**KIRKLEES METROPOLITAN COUNCIL
INVESTMENT & REGENERATION SERVICE**

**DELEGATED DECISION FOR APPLICATION FOR CERTIFICATE OF
LAWFUL DEVELOPMENT**

Reference no.: 2025/CL/93496/W
Site: 86, Fixby Road, Fixby, Huddersfield, HD2 2JF
Description: Certificate of lawfulness for proposed rear dormer
Case Officer: Laura Yeadon

Decision Reference: CERTIFICATE OF LAWFUL OPERATIONS REFUSED

DRAWING TITLE
Proposed Elevations

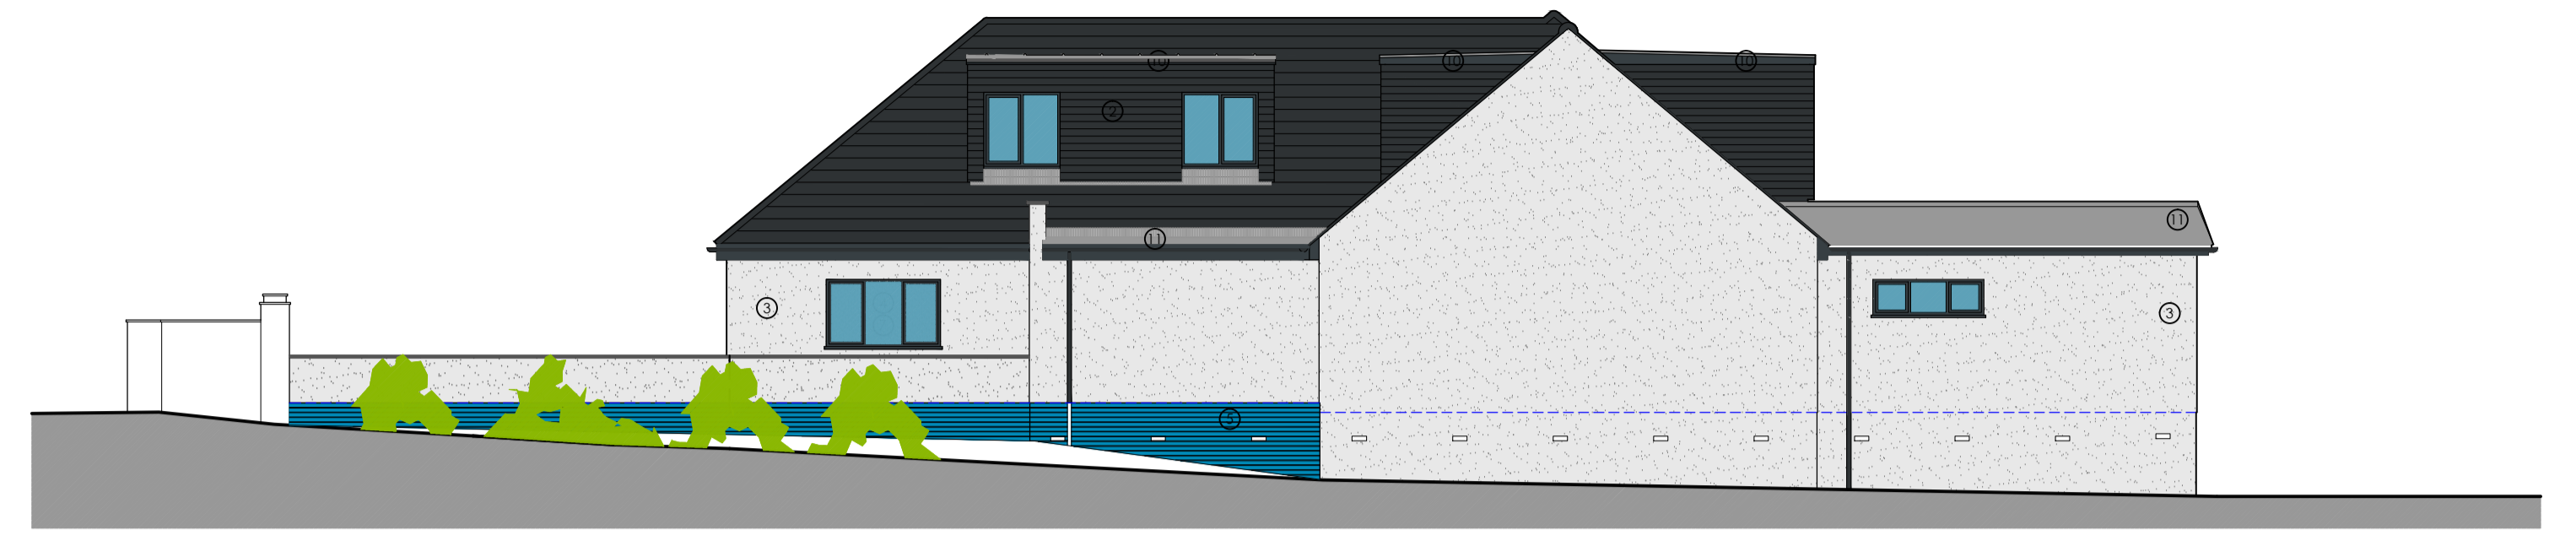
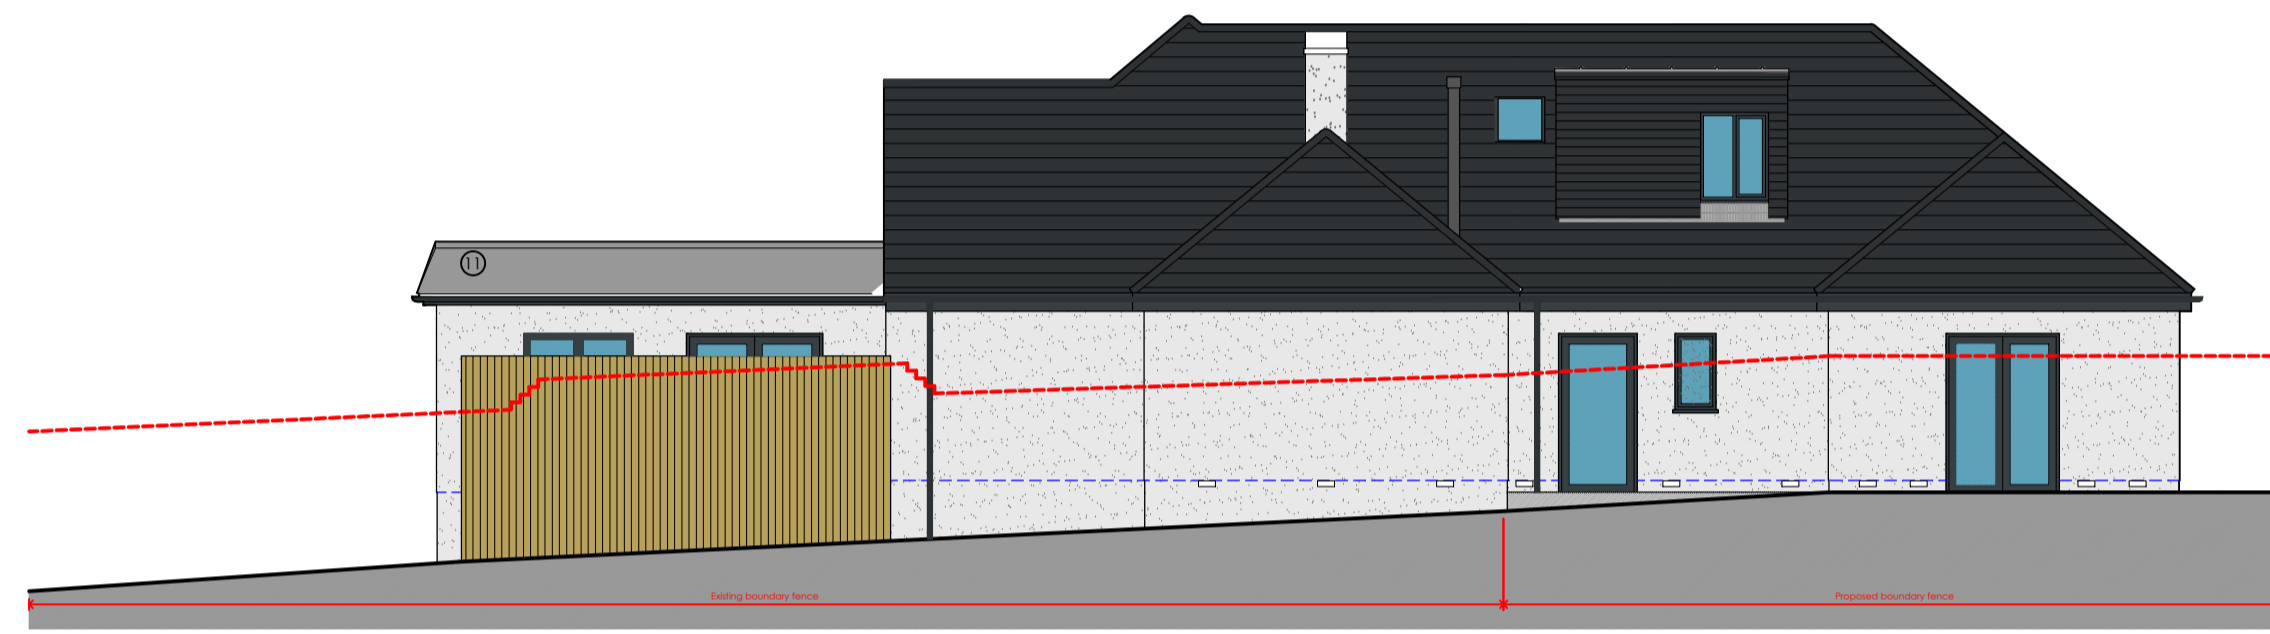
A dormer is proposed on the rear elevation, set back from the existing eaves by approximately 1.3 metres being a width of 11.2 metres. The dormer would project approximately 1.9 metres from the roof ridge and would be a total height of 2 metres. The total cubic volume increase would be approximately 19.75 m³ although the information within the Supporting Statement cites this as being 25.63m³.

Comment: *The calculations submitted by the Agent cite that the total roof additions including those within the approved 2024/91759 application equates to 49.25 cubic metres thereby according with this part of the GPDO. However, this calculation does not take into account the addition of the roof form of the single storey rear extension under the same approved planning application (albeit reduced in size as part of the Non Material Amendment application which is currently under consideration). This proposal attaches to the existing roof form and adds further volume to the roof form which would increase the cumulative roof form from the 2024 application to over 50m³. That being said, it is unclear as to whether or not the above aforementioned permission has been implement, completed and habitable.*

As can be seen from the above aerial images, the roof form of the building has been extended in excess of 50cm³ from the original property and therefore the application fails to meet this criteria.

The proposed rear dormer extension as shown on the submitted plans listed in this decision notice does not benefit from a general planning permission granted under Article 3(1) and Schedule 2, Part 1 (Development within the curtilage of a dwelling house), Class B of the Town and Country Planning (General Permitted Development)(England) Order 2015 (as amended) as the proposal exceeds the resultant roof space limitation as set out in subparagraph B.1(d) and B.3 of Class B.
